**St MATTHEWS CATHOLIC COLLEGE, MUDGEES (SSD 9872)
CORNER BROADHEAD ROAD AND BRUCE ROAD, SPRING FLAT (MUDGEES)
RESPONSE TO SUBMISSIONS**

RESPONSE TO DPIE KEY ISSUES AND AGENCY, COUNCIL & PUBLIC SUBMISSIONS

**BROADHEAD ROAD AND BRUCE ROAD**  
SCALE 1:200 AT A1

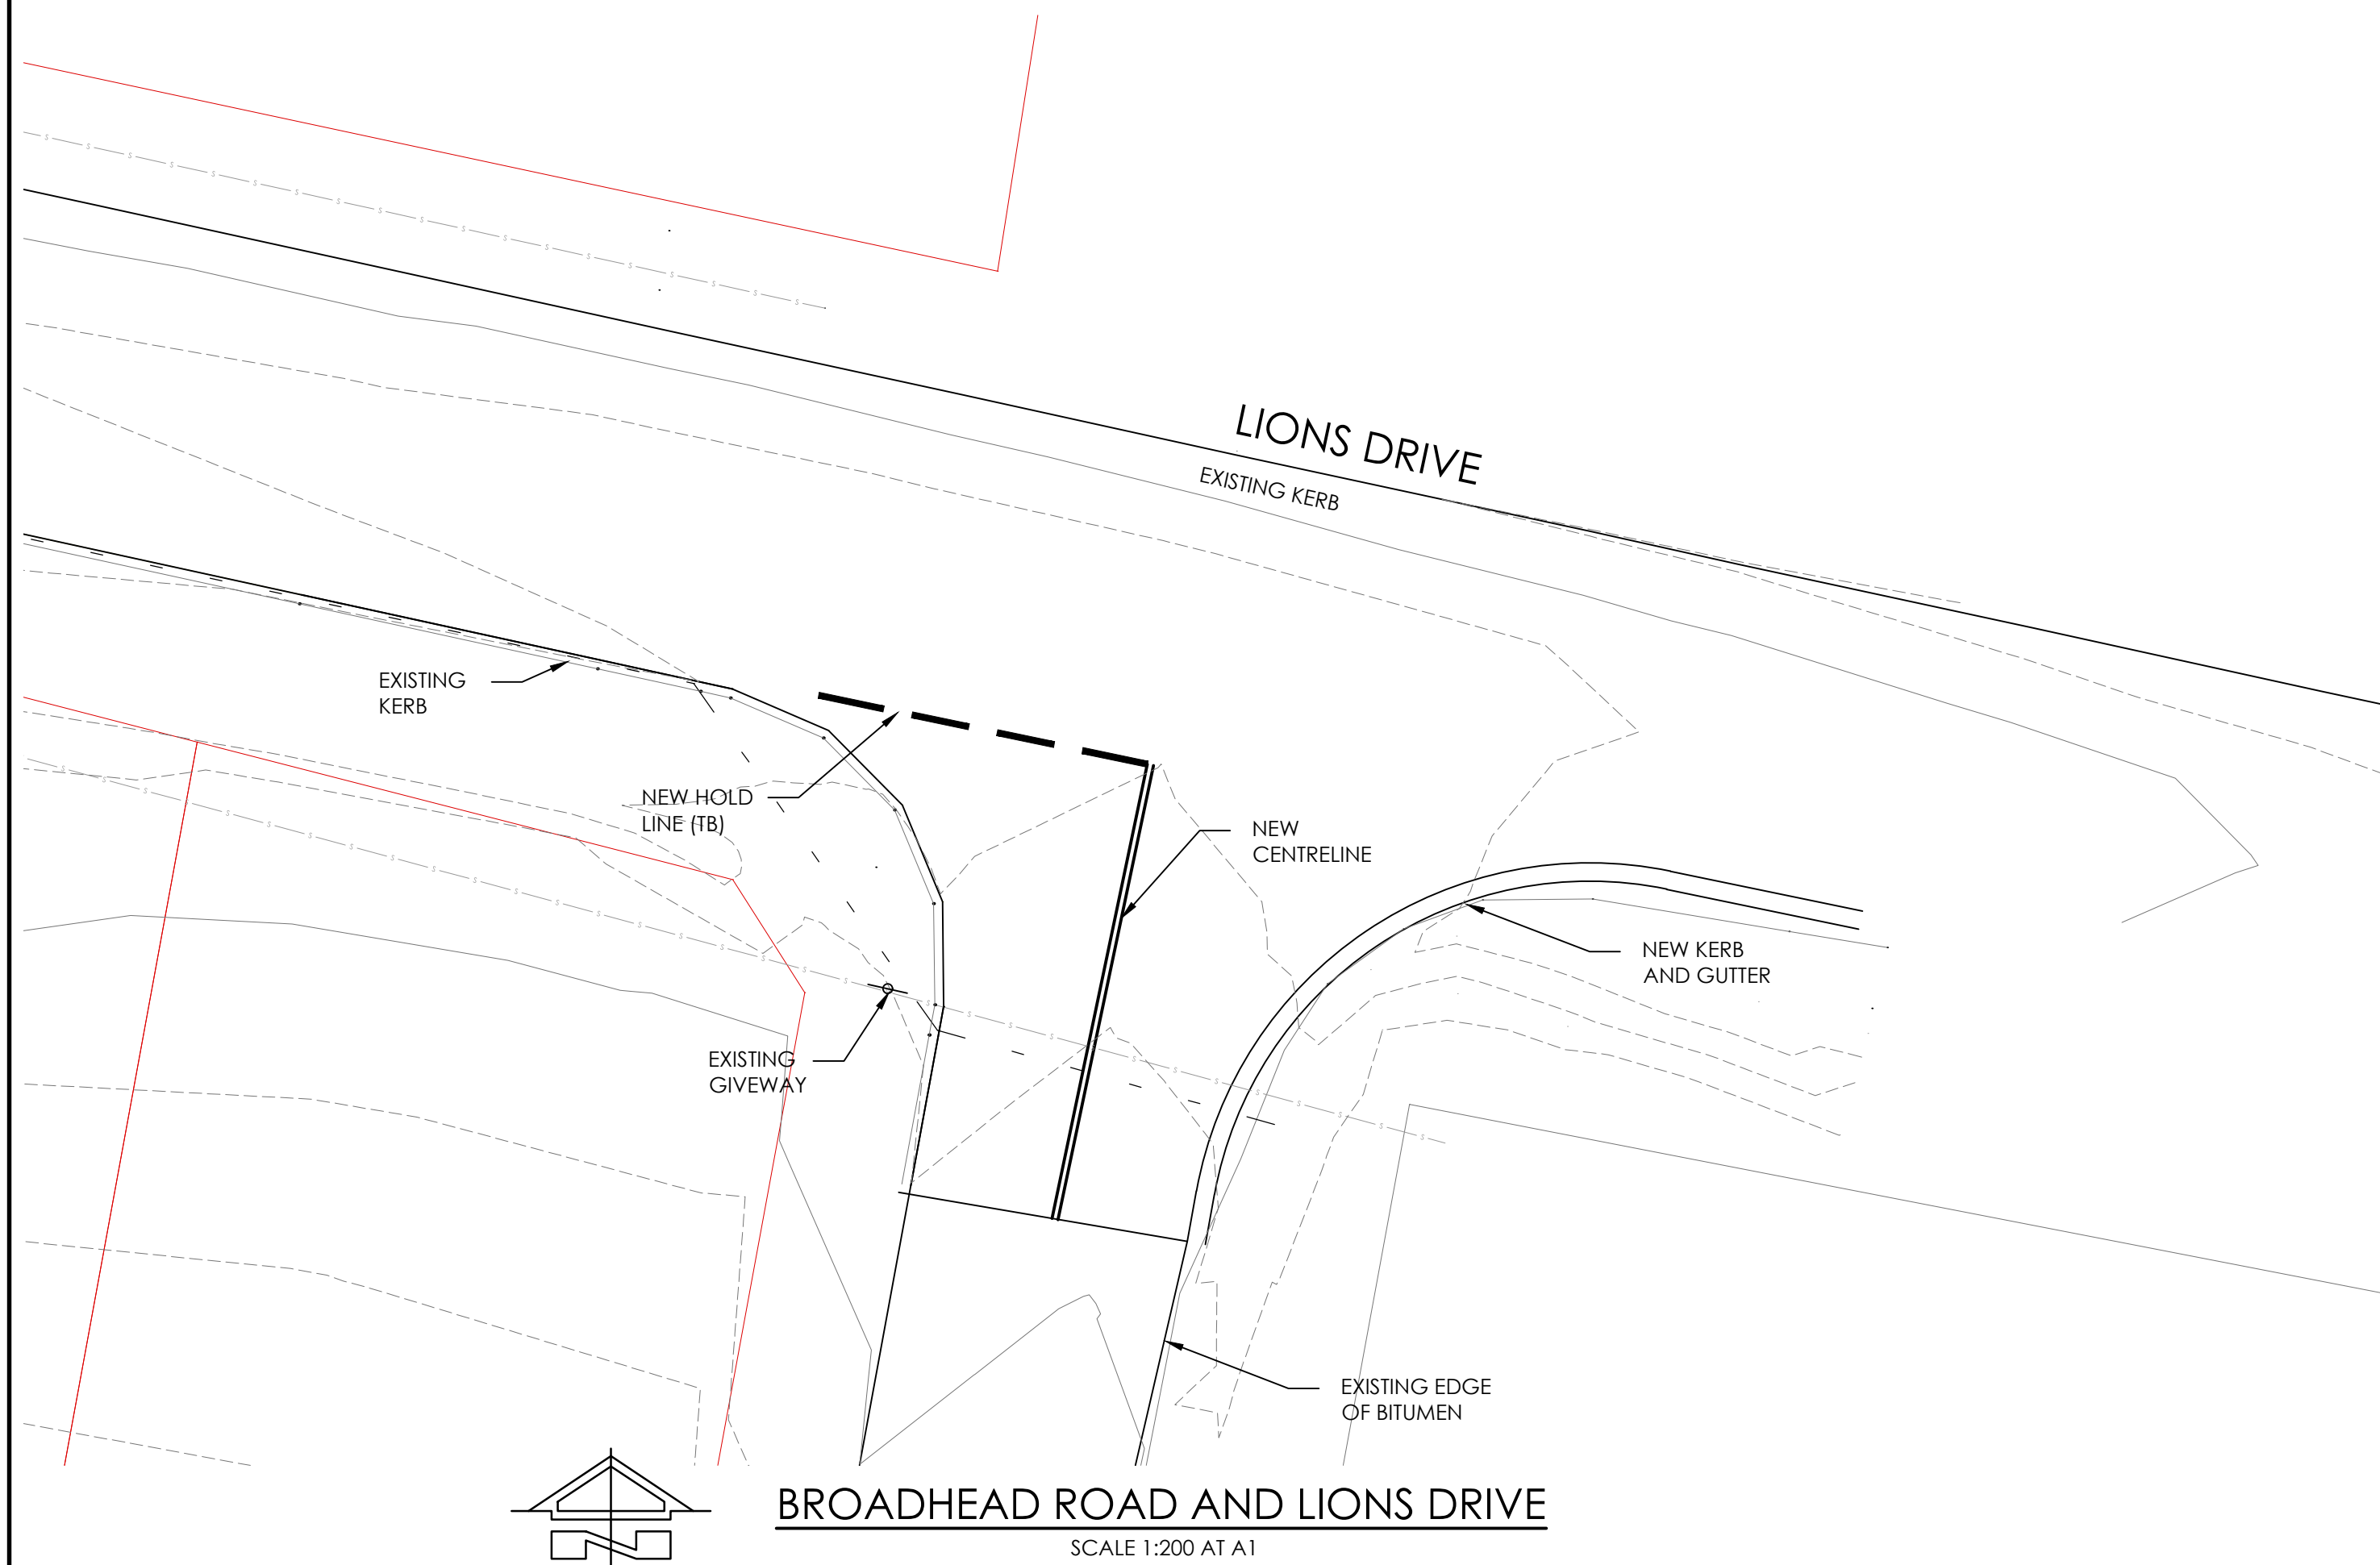
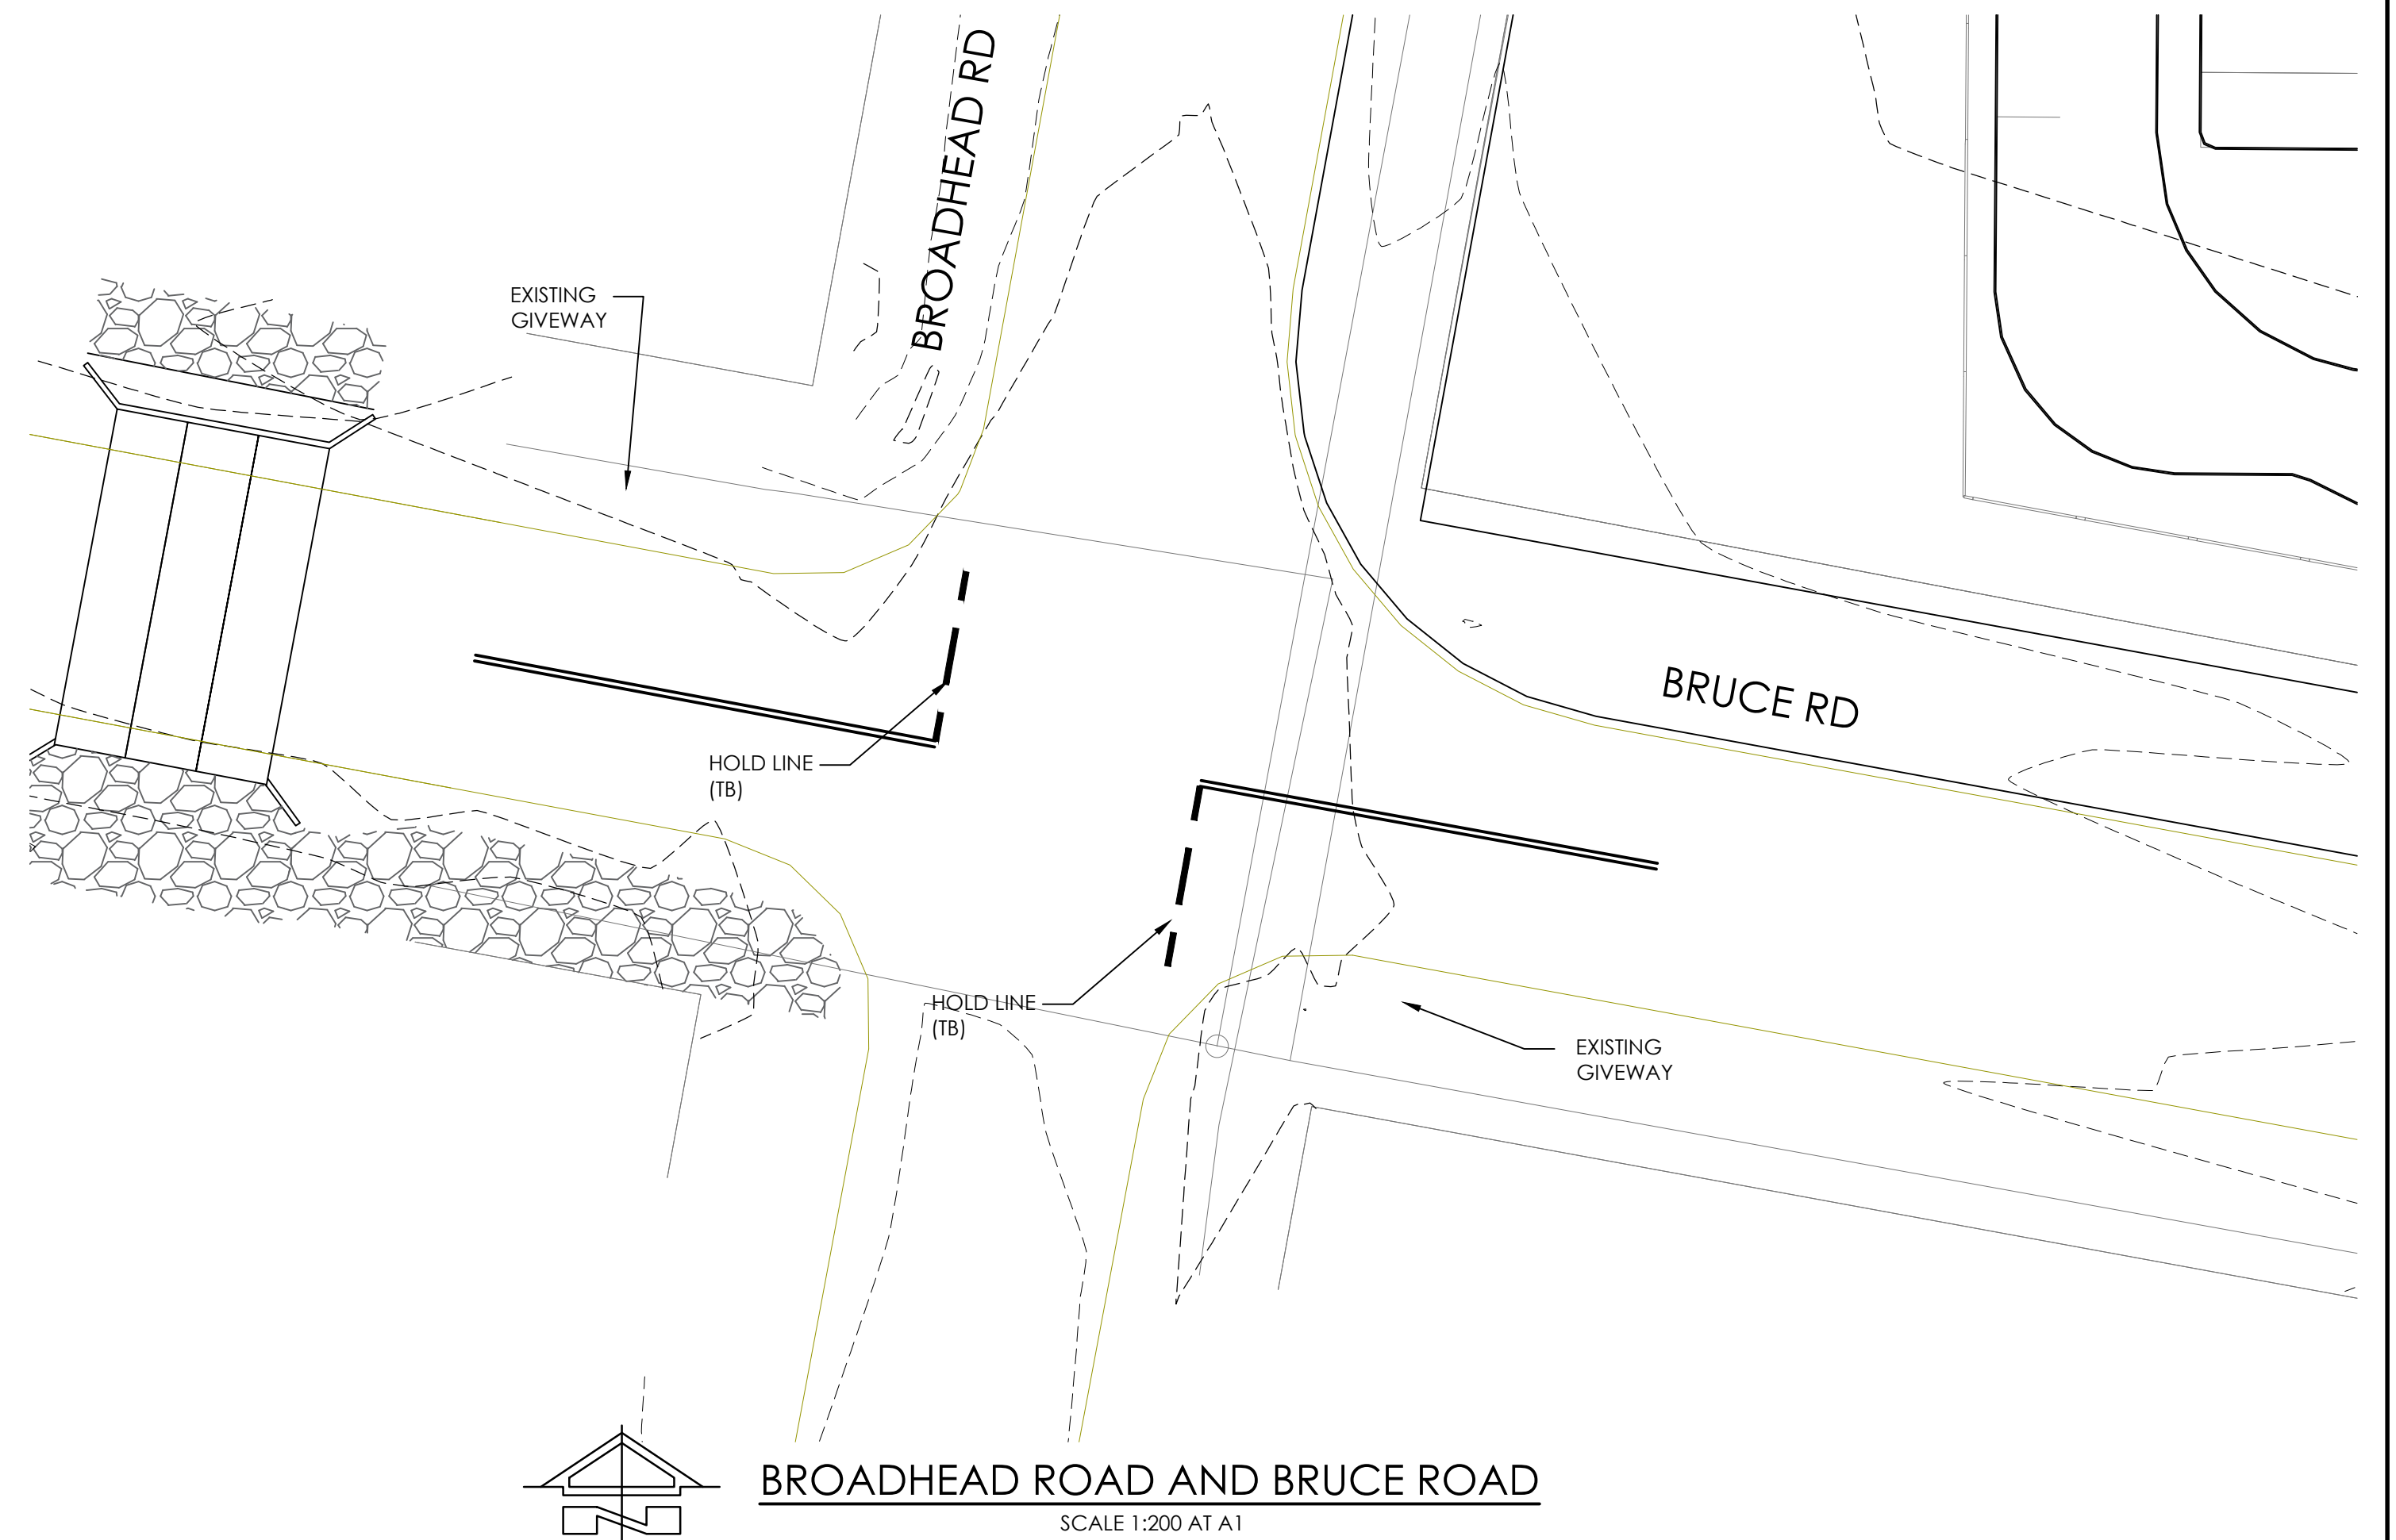
<ul style="list-style-type: none"> The transition from 9 metre pavement width to 6 metre pavement width on Bruce Road after the bus bay should be increased to 7.2 metres, so that that the width is consistent with the rest of Bruce Road to Spring Flat road upgrade; 	<p>As above.</p>
<ul style="list-style-type: none"> Upgrade to 4 x intersections (Broadhead Road and Lions Drive intersection, Broadhead Road and Bruce Road intersection, Lions Drive and Robertson Road intersection, Bruce Road and Robertson Road intersection) to provide for acceptable bus turning swept paths and pavement treatment, which may include AC surfacing and splitter islands for pedestrian refuges; and 	<p>In our recent meeting with Council it was confirmed that the wording of this particular matter suggests a range of uniformly comprehensive intersection upgrades, but this however was not the intent.</p> <p>Council advised that a better approach would have been a review of each intersection for an upgrade need (and scope if required) on a case by case basis. As noted, the applicant is already committed to the Broadhead Road-related intersection upgrades (at Bruce and Lions, respectively) to cater for bus movements, but do not agree that those works related to Robertson Road (at Bruce and Lions, respectively) warrant bus-scaled improvements, particularly as Robertson Road</p>

<p>intersections can already cater for bus movements – see swept analysis at Appendix H.</p> <p>Council agreed that the road intersection upgrade works would be related to whether bus traffic would be using those intersections and whether the existing intersections warranted any form of upgrade to meet increased traffic volume levels.</p> <p>Based on this, the bus-related intersections of Broadhead Road & Lions Drive and Broadhead Road & Bruce Road are agreed to be upgraded as follows:</p> <p>Broadhead Road and Lions Drive intersection</p> <ul style="list-style-type: none">• New centre line at the intersection within Broadhead Road;• New hold line for northbound traffic within Broadhead Road at Lions Drive; and• New kerb and gutter from Lions Drive south-bound into Broadhead Road. <p>Broadhead Road and Bruce Road intersection (in addition to the proposed roadworks)</p> <ul style="list-style-type: none">• New centre lines on Bruce Road west bound and east bound at the intersection;• New hold lines for west bound and east bound traffic on Bruce Road at the intersection. <p>The lighter vehicle intersections of Lions Drive & Robertson Road and Bruce Road & Robertson Road are proposed to be upgraded as follows:</p> <p>Lions Drive and Robertson Road intersection</p> <ul style="list-style-type: none">• New centre line on Lions Drive west bound at the intersection; and• New hold line for west bound traffic on Lions Drive at the intersection. <p>Bruce Road and Robertson Road intersection</p> <ul style="list-style-type: none">• New centre lines on Bruce Road west bound and east bound at the intersection; and• New hold lines for west bound and east bound traffic on Bruce Road at the intersection. <p>It is noted that whilst the Robertson Road intersections can presently cater for bus movements, Ogden’s bus routes (the school’s transport provider) do not utilise these routes or intersections to service the area and will not likely uses these to service the school in this location.</p> <p>Triaxial intersection analysis plans and swept paths are found at Appendix H.</p>
